**Consultation Response from KC,
Highways Development Management****2022/91730 Land Adjacent, 60, Northgate, Cleckheaton, BD19 3NB****Demolition of former dairy/snooker centre/storage and erection of 9 light industrial units****Date Responded: 10-8-2022****Responding Officer: Mark Berry****Responding Ref: 9-6NW-14**

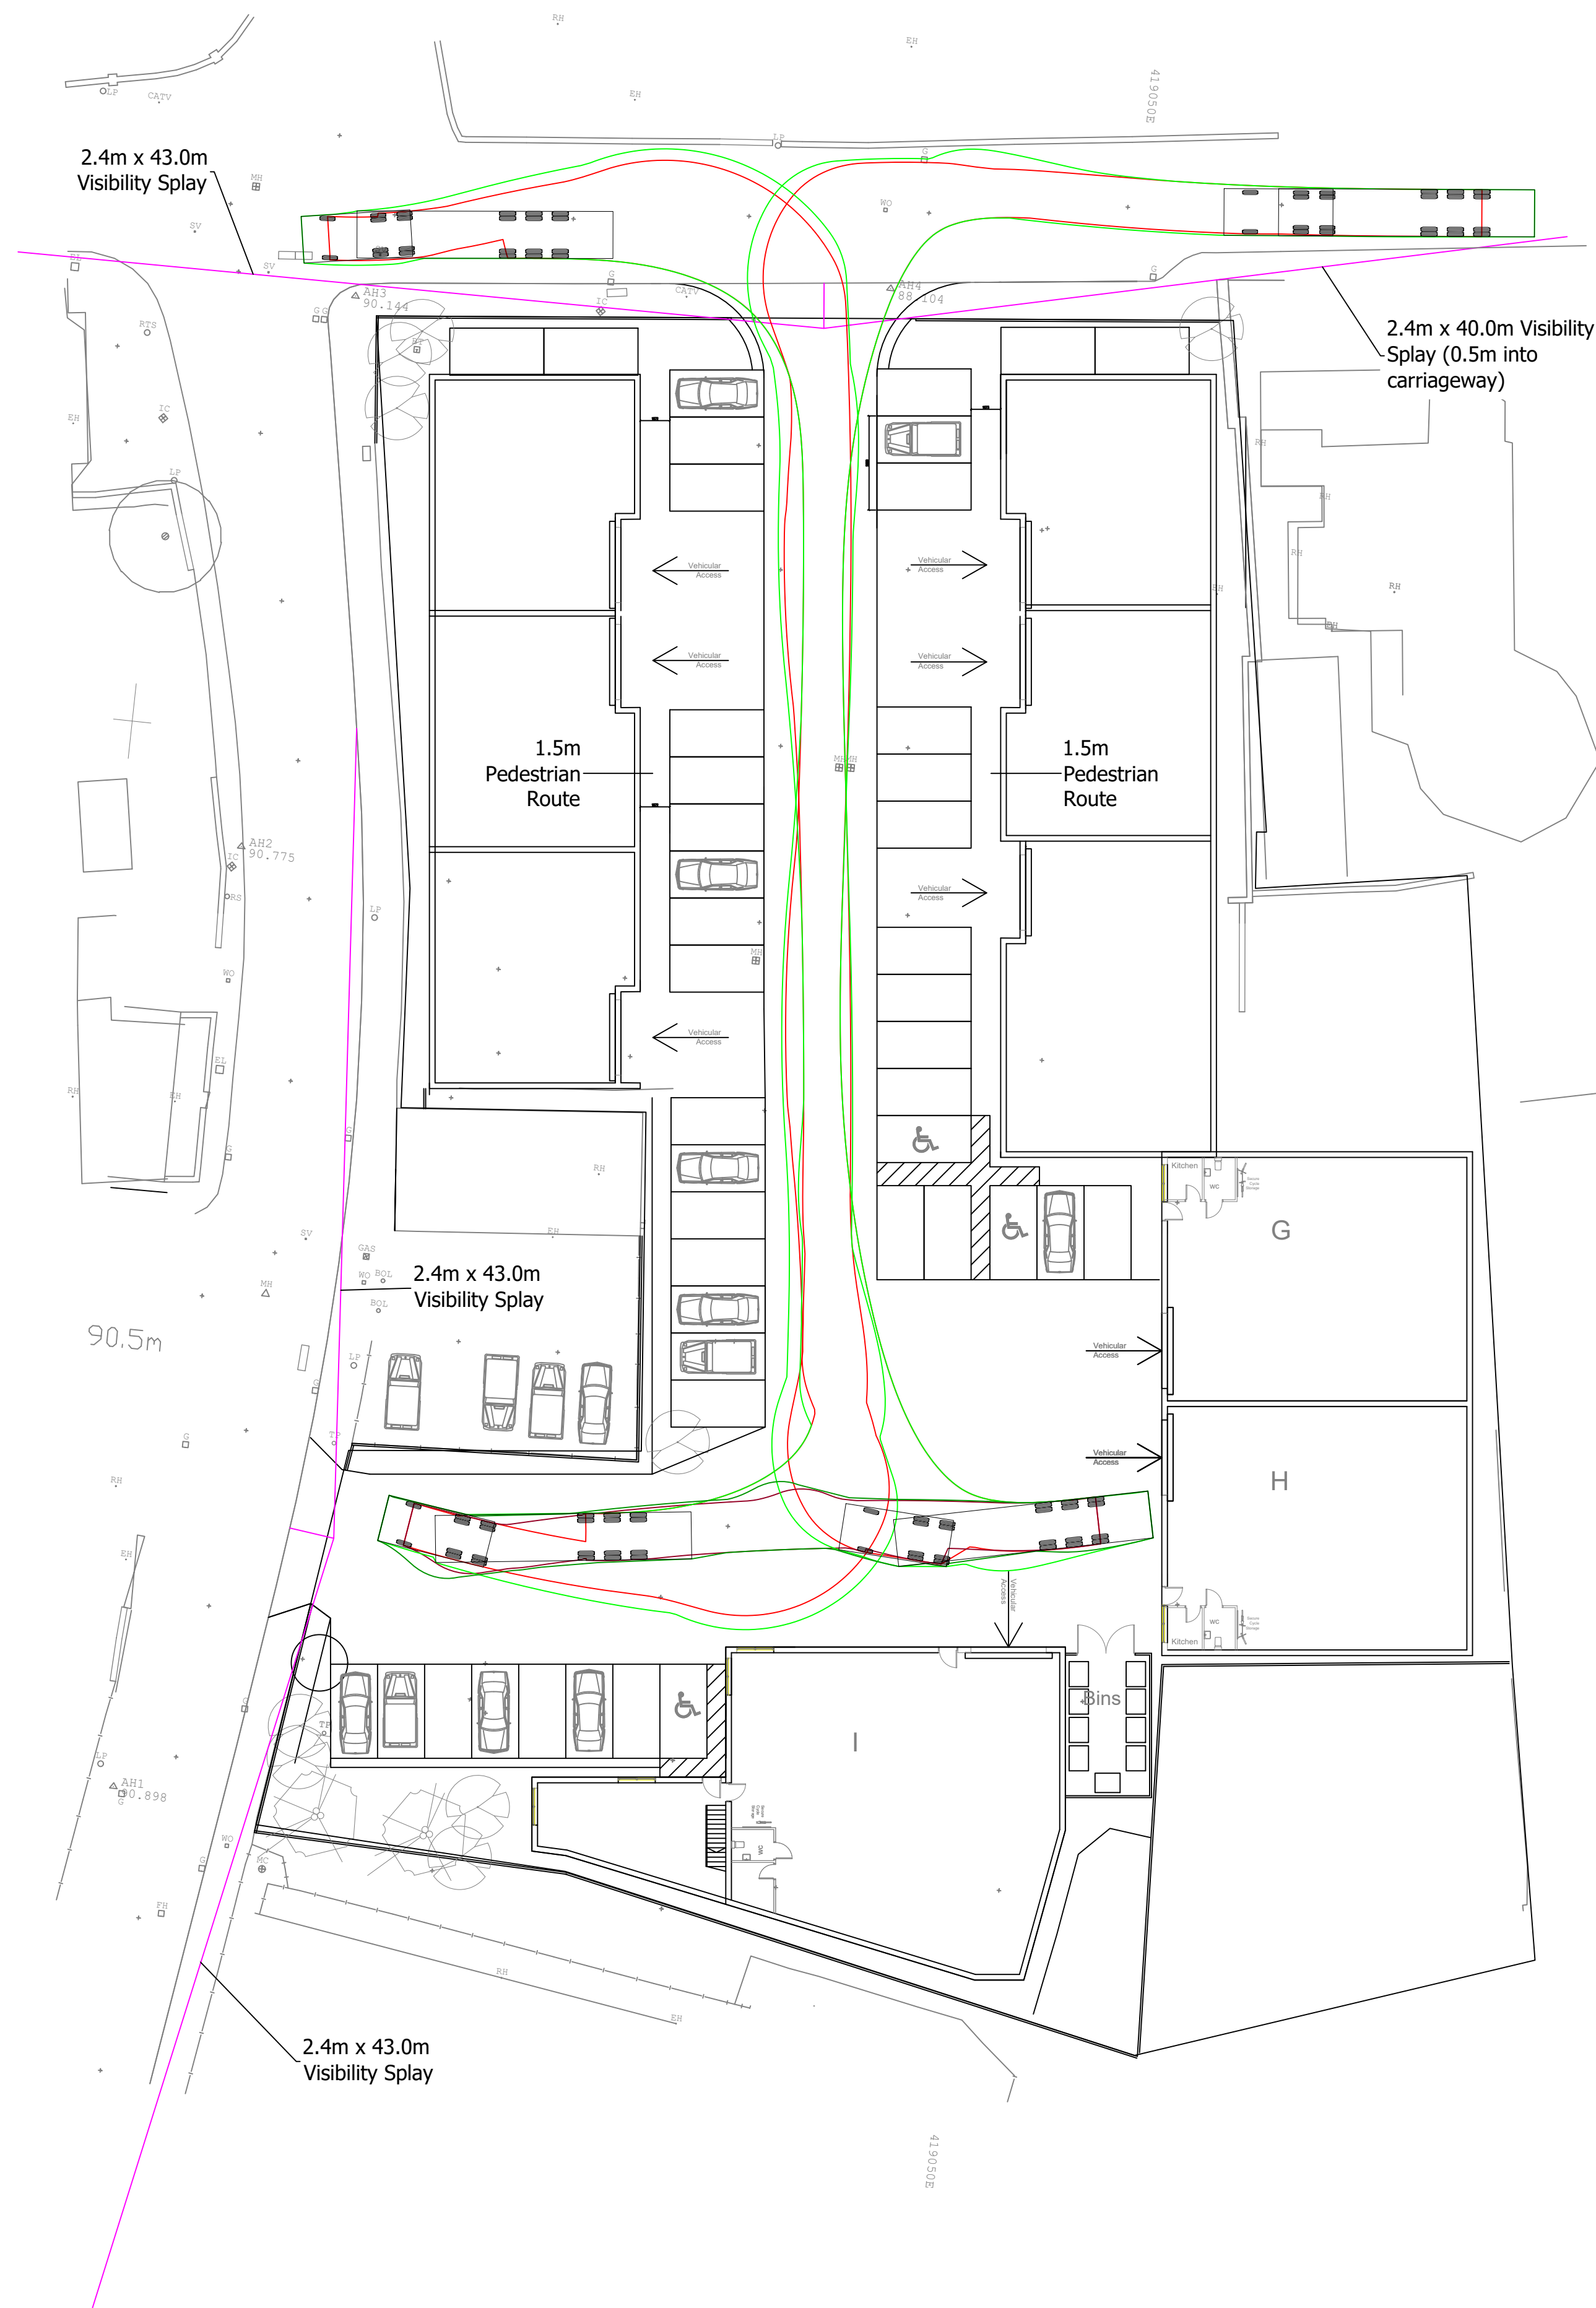
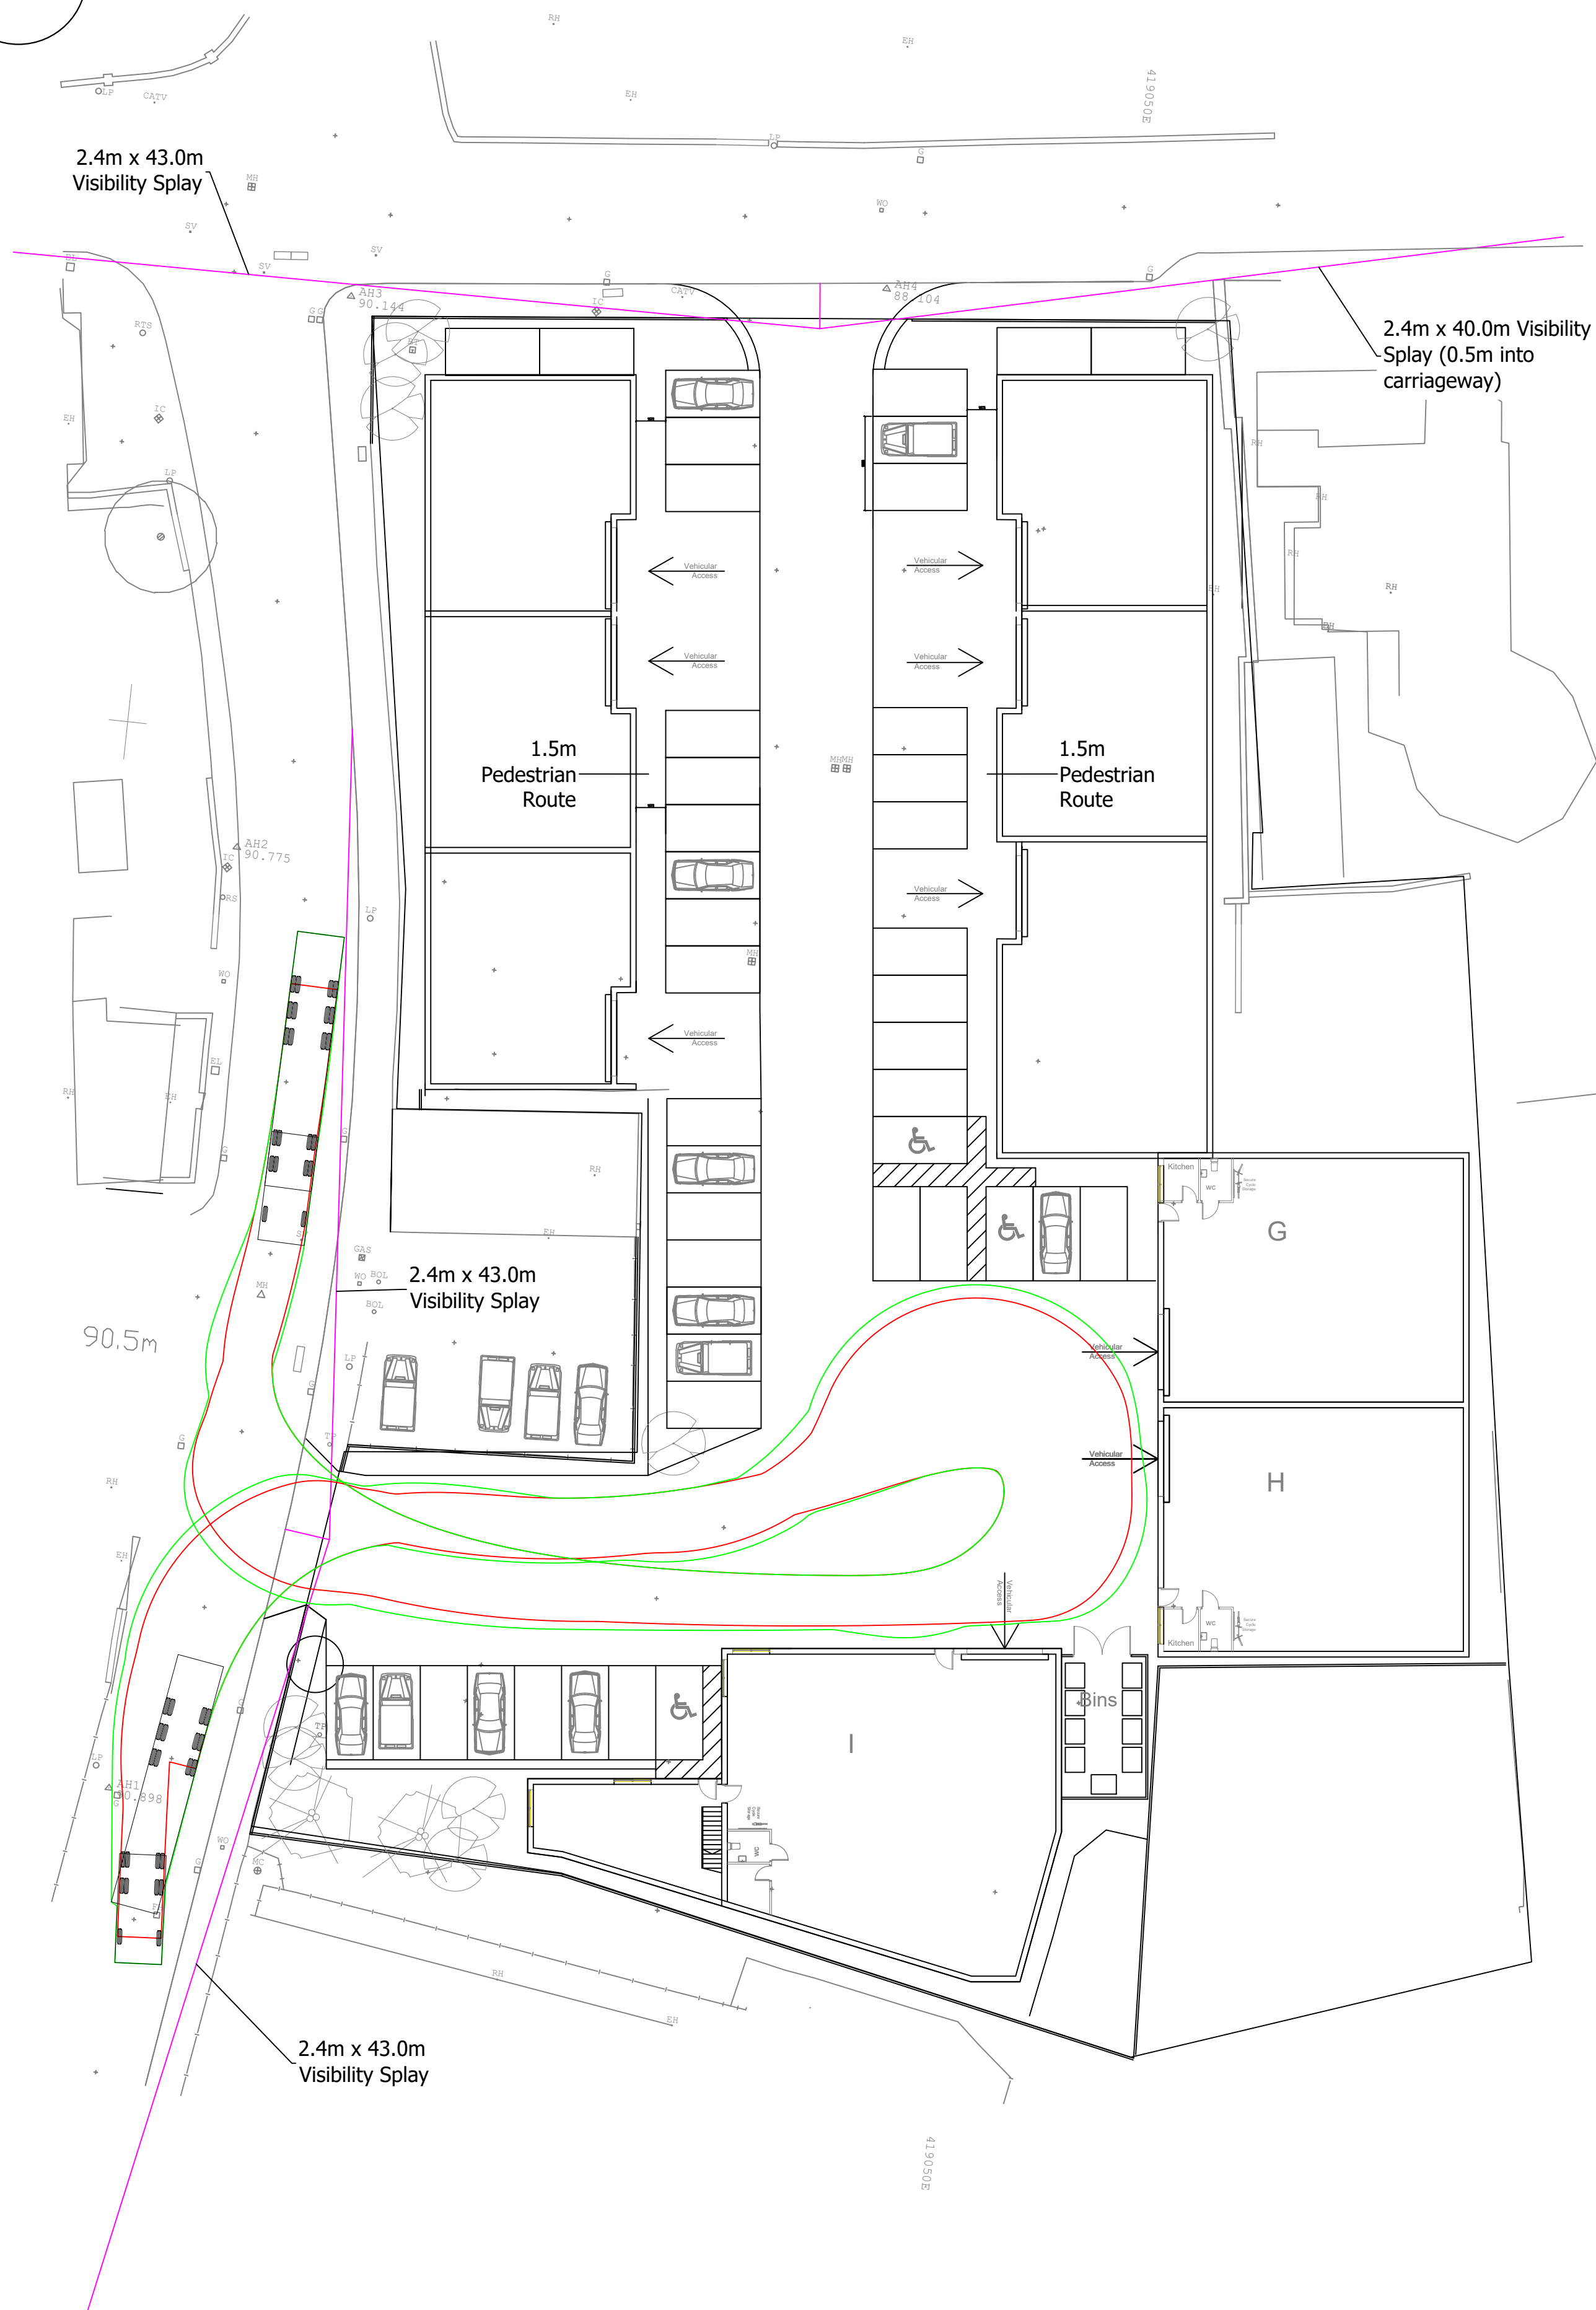
There are no pedestrian facilities shown to be provided through the site just a carriageway with parking to either side. Pedestrian routes should be shown to be provided through the site.

There are no details of the proposed sight lines from either access onto Northgate or Scott Lane.

A 16.5m articulated lorry should be tracked not just a refuse vehicle and van. The servicing arrangements are not therefore shown to be acceptable.

Fore court depths should be a minimum of 10.0m with a 600mm overhang strip around the extent of the adoptable or private industrial road (Highway Design Guide Section 3.23).

Both accesses should have appropriate kerb radii which should be determined by 16.5m articulated lorry swept paths.
